MONUMENT GLAMPING SITE PLAN
16315 RICKENBACKER AVE.
MONUMENT, CO 80132

SITE PLAN

SITE PLAN

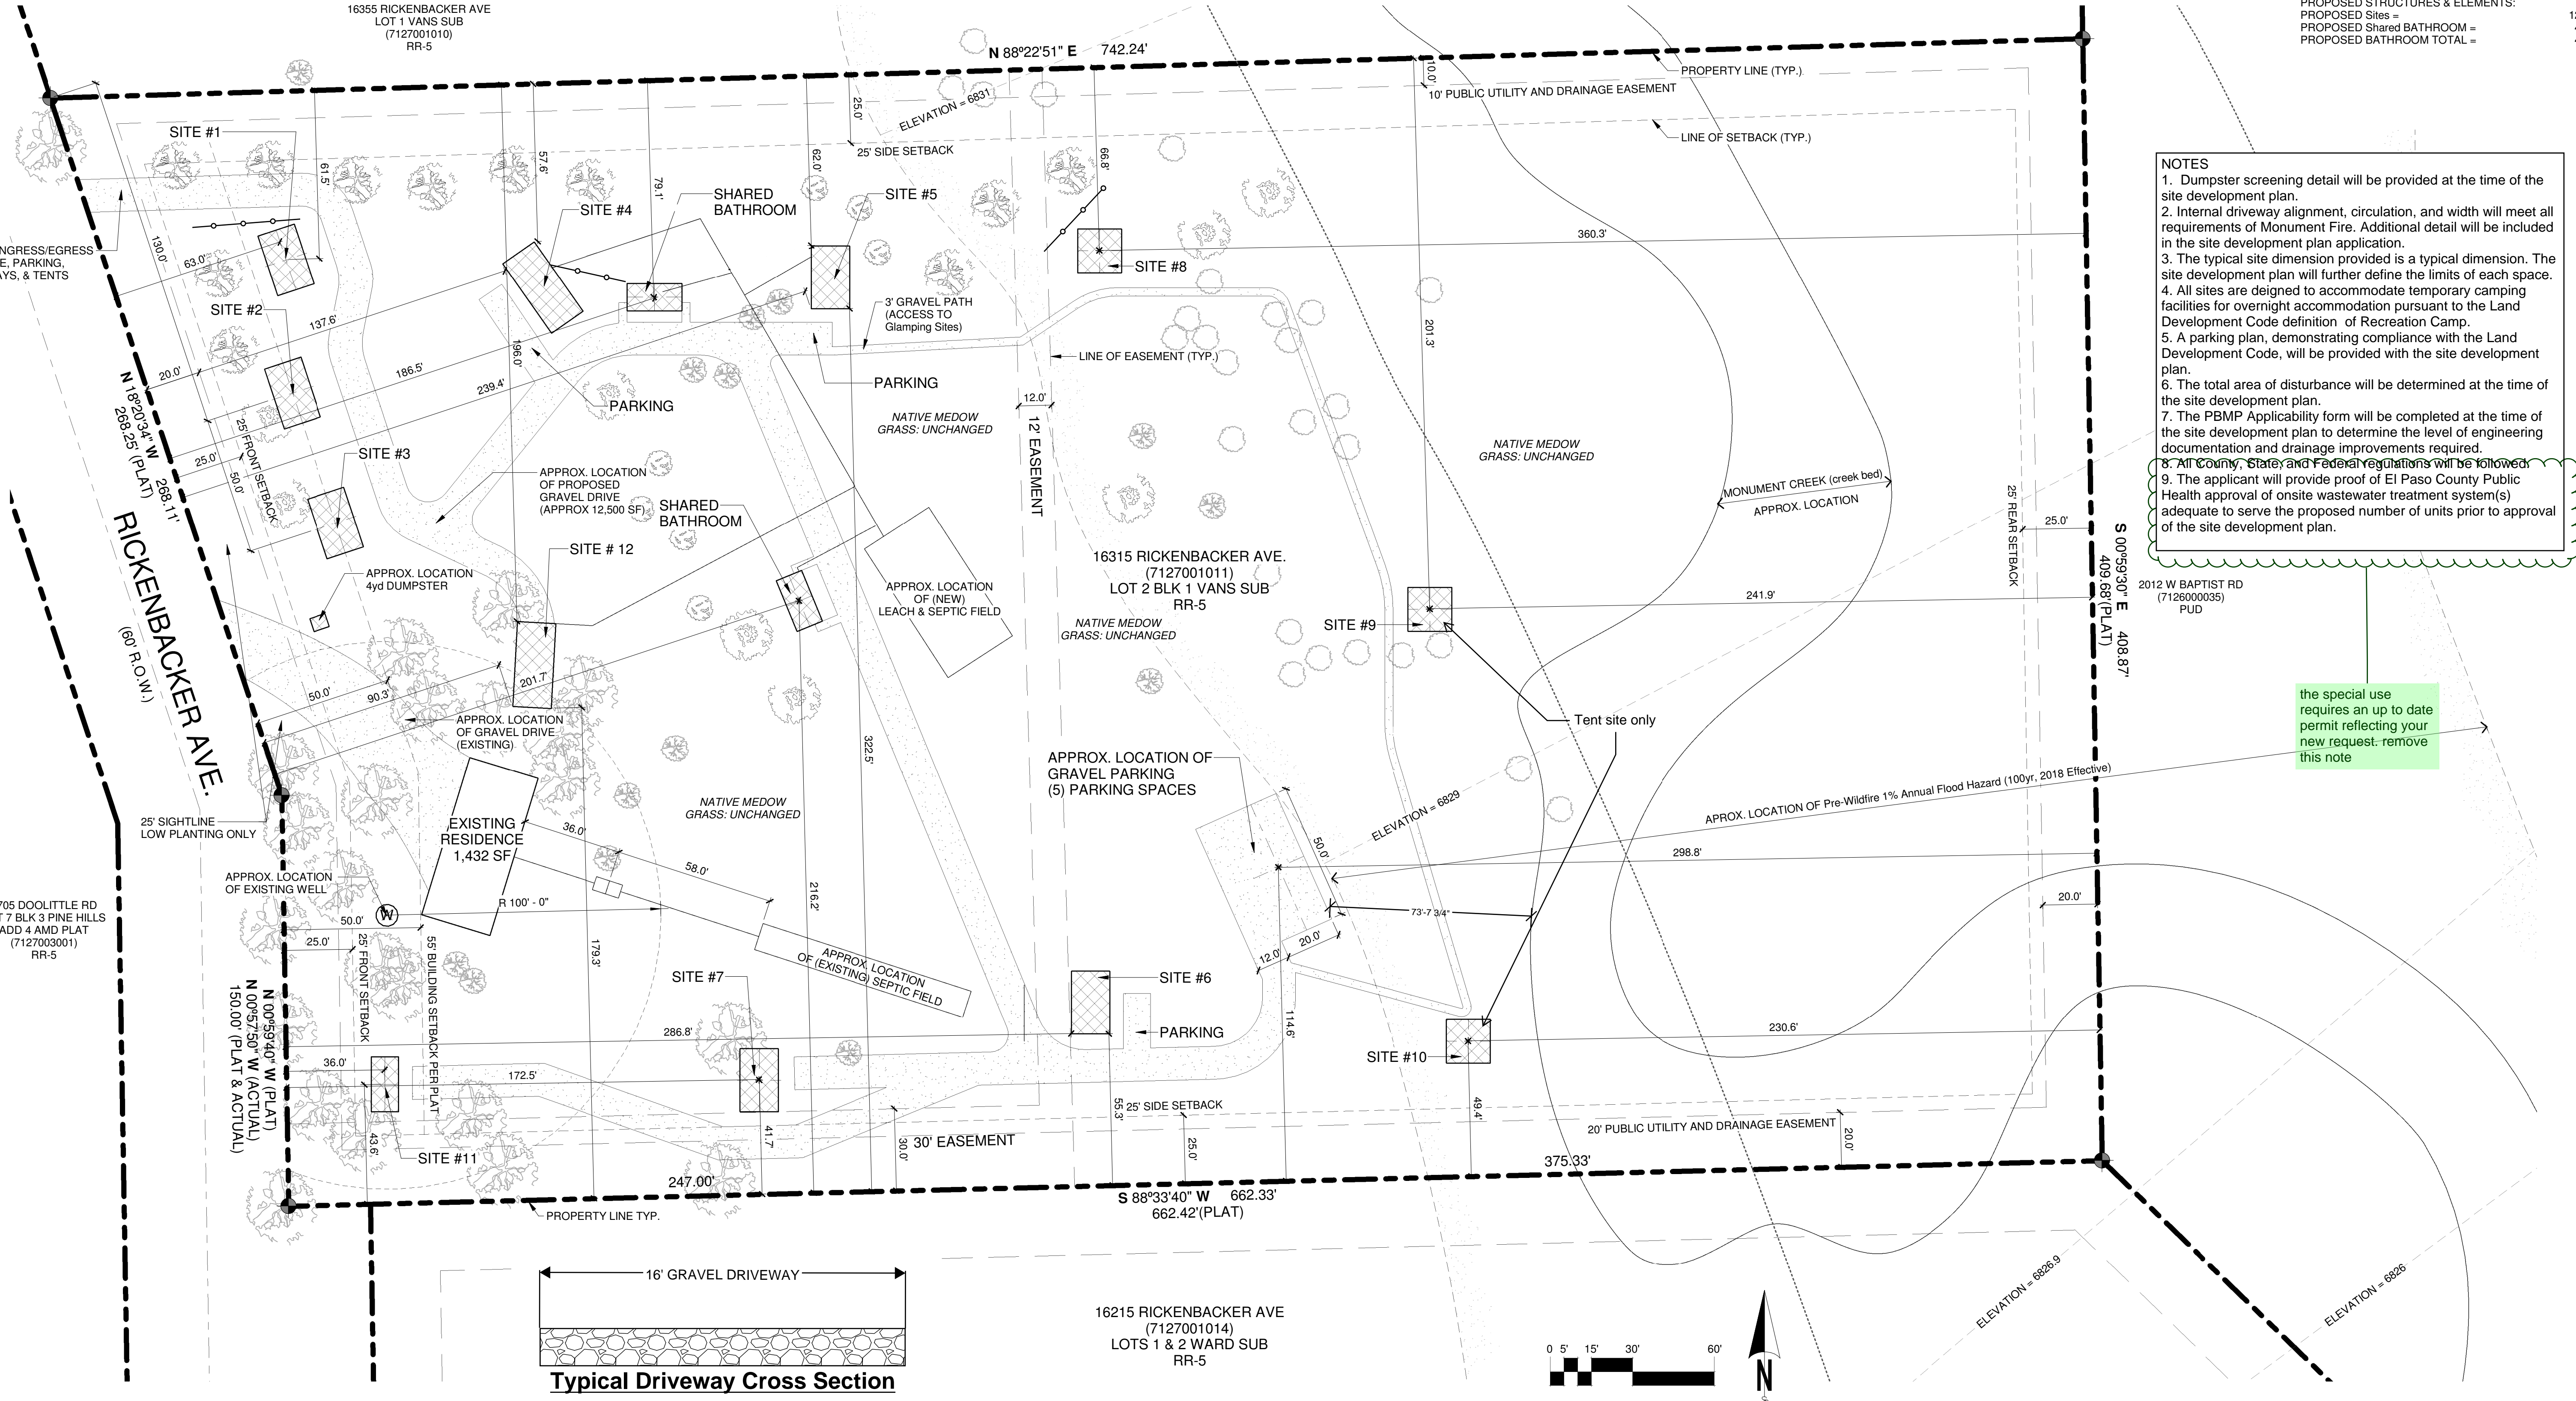
1432 + 480 + 3134 + 210 = 5,256
Please Revise

These numbers are the same as previous submittal and the proposal is asking for 4 more sites being added which means these numbers should change
Please Revise

Per the parking table, 1 spot per room, please update parking

Please include:
-what type of structure each site is
-what is the sq footage of each site
-where is the RV that has been on the previous reviews?

Please submit a secondary driveway access permit for the new driveway. Instructions will be provided in the EDARP review comment.

Please depict the type of structure

Please provide measurements of parking lot to creek

Please depict the type of structure

Provide adequate radius turn around point
One way access road min of 16ft in width per LDC 6.3.3. with two way 24ft. If the access roads dont meet width requirements a waiver may be required.
Address internal access roadway width and circulation as its not clear where the turnaround points are located
